Our Ref SA.NP.LIMA/2989872-0001

Date 21<sup>st</sup> April 2016

**Re Town and Country Planning Act 1990  
Application Reference : 6/2016/0391/VAR  
Property : 45 Northaw Road East, Cuffley**

Side Elevation Proposed

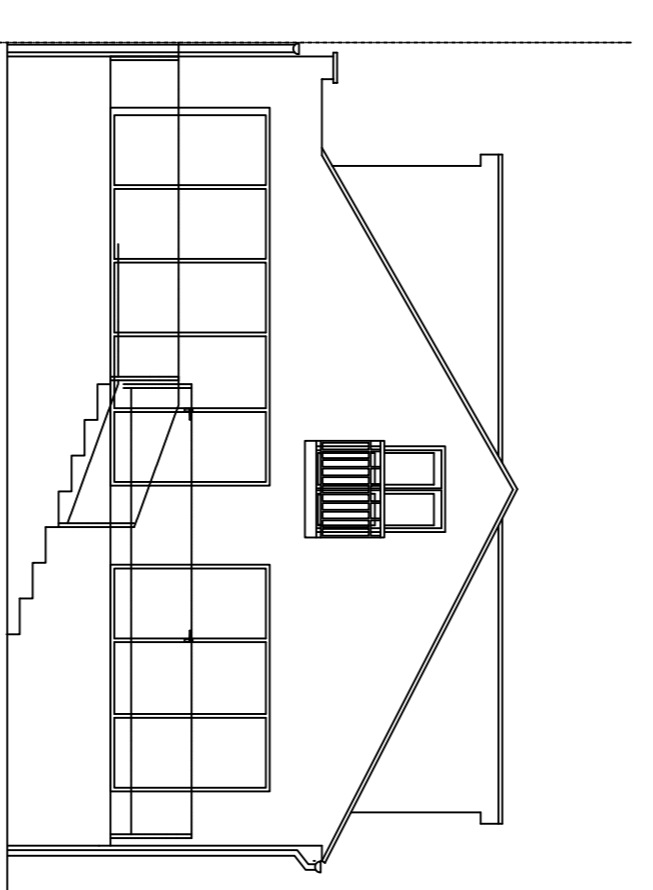
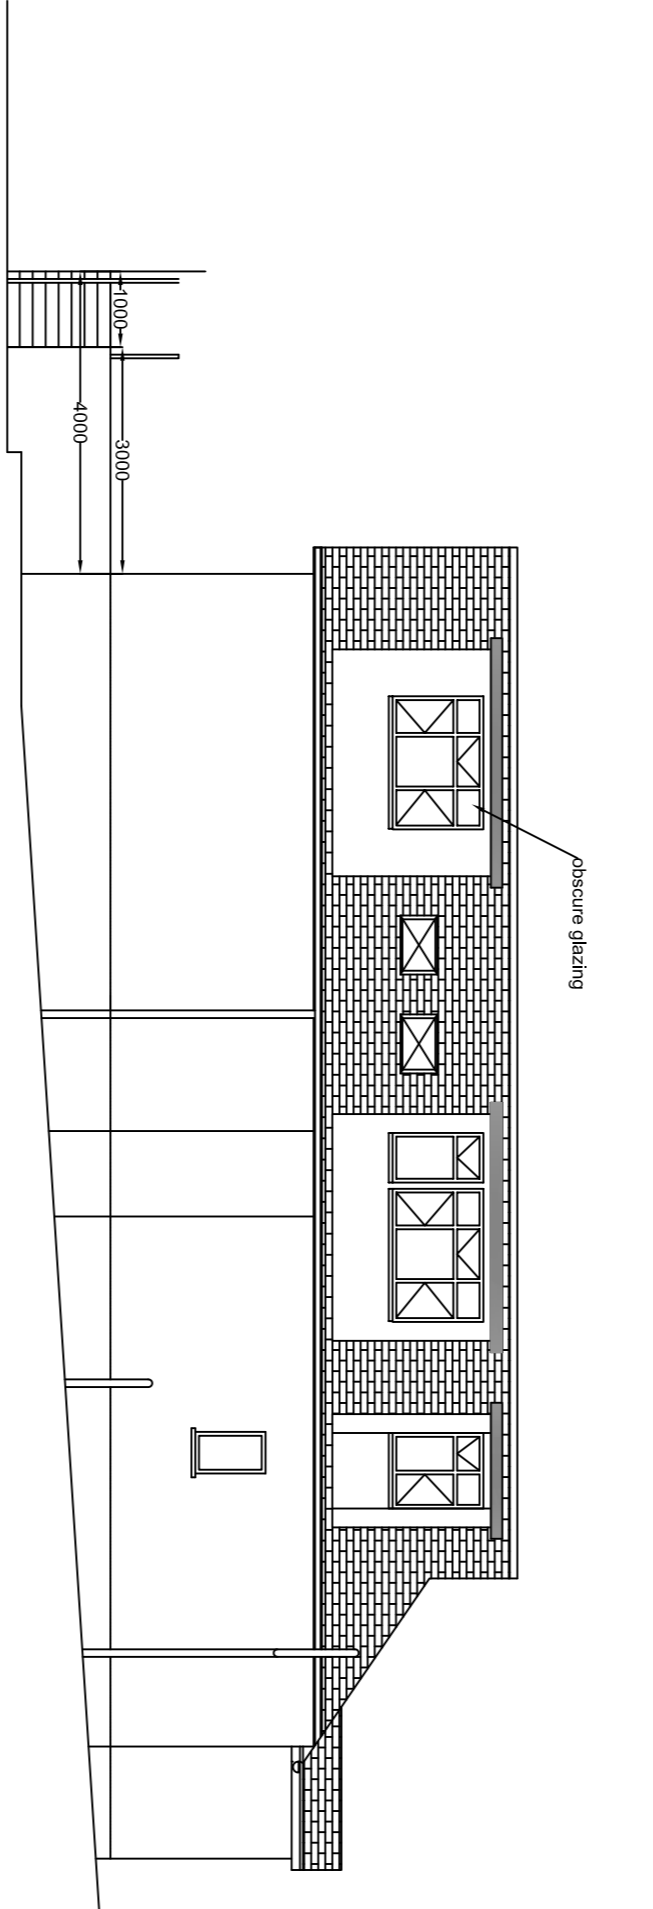
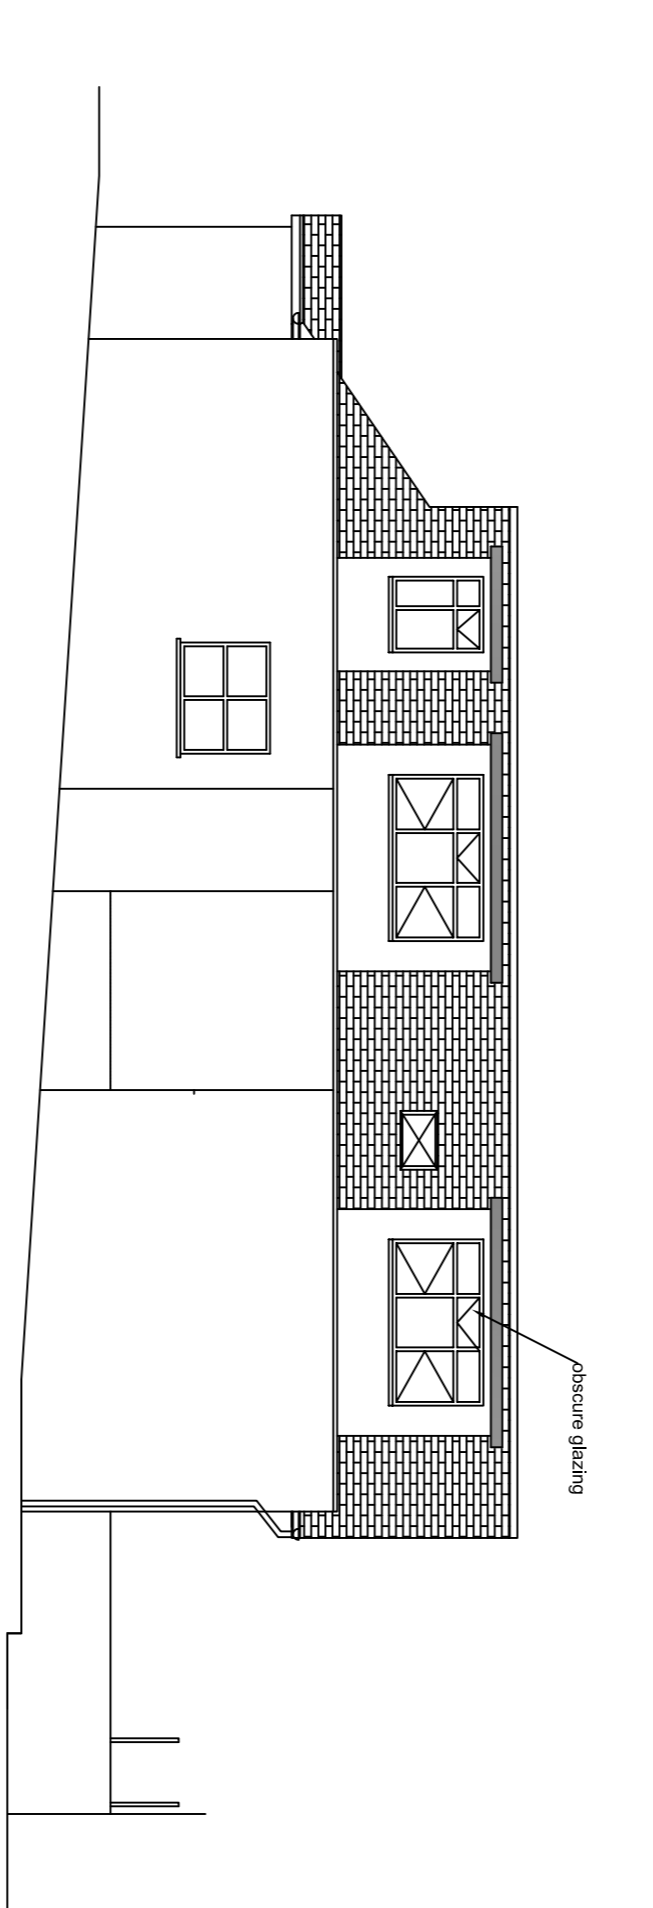
The wall of the dwelling is taller, resulting in a ridge height which is greater than that which was originally approved. This has a knock-on-effect on the height of the dwelling. We are also instructed that there are discrepancies between the arrangements of the fenestration facing our clients property which is still not accurately reflected in the drawings submitted with the Variation Application. We are instructed that within the middle dormer facing our clients' property there is an additional single window that has been installed. This should be removed as it does not form part of the plans of the Original Application and it is not shown in the Variation Application.

The Planning Officer will also be aware of the omission in the approved permission of a condition to obscure the windows facing our clients' property in order to reduce overlooking. The officer that dealt with the permission approved stated in her report that the side dormers "will be fixed and obscure glazed by way of planning condition" in order to prevent overlooking to our clients at No.43. That condition was never included within the Planning Permission and we would therefore respectfully ask, although our client objects to this application, that this condition is included should officers be minded to grant permission. Once again we reiterate that the fenestration installed at the property is not accurately reflected on the drawings submitted with the Variation Application.
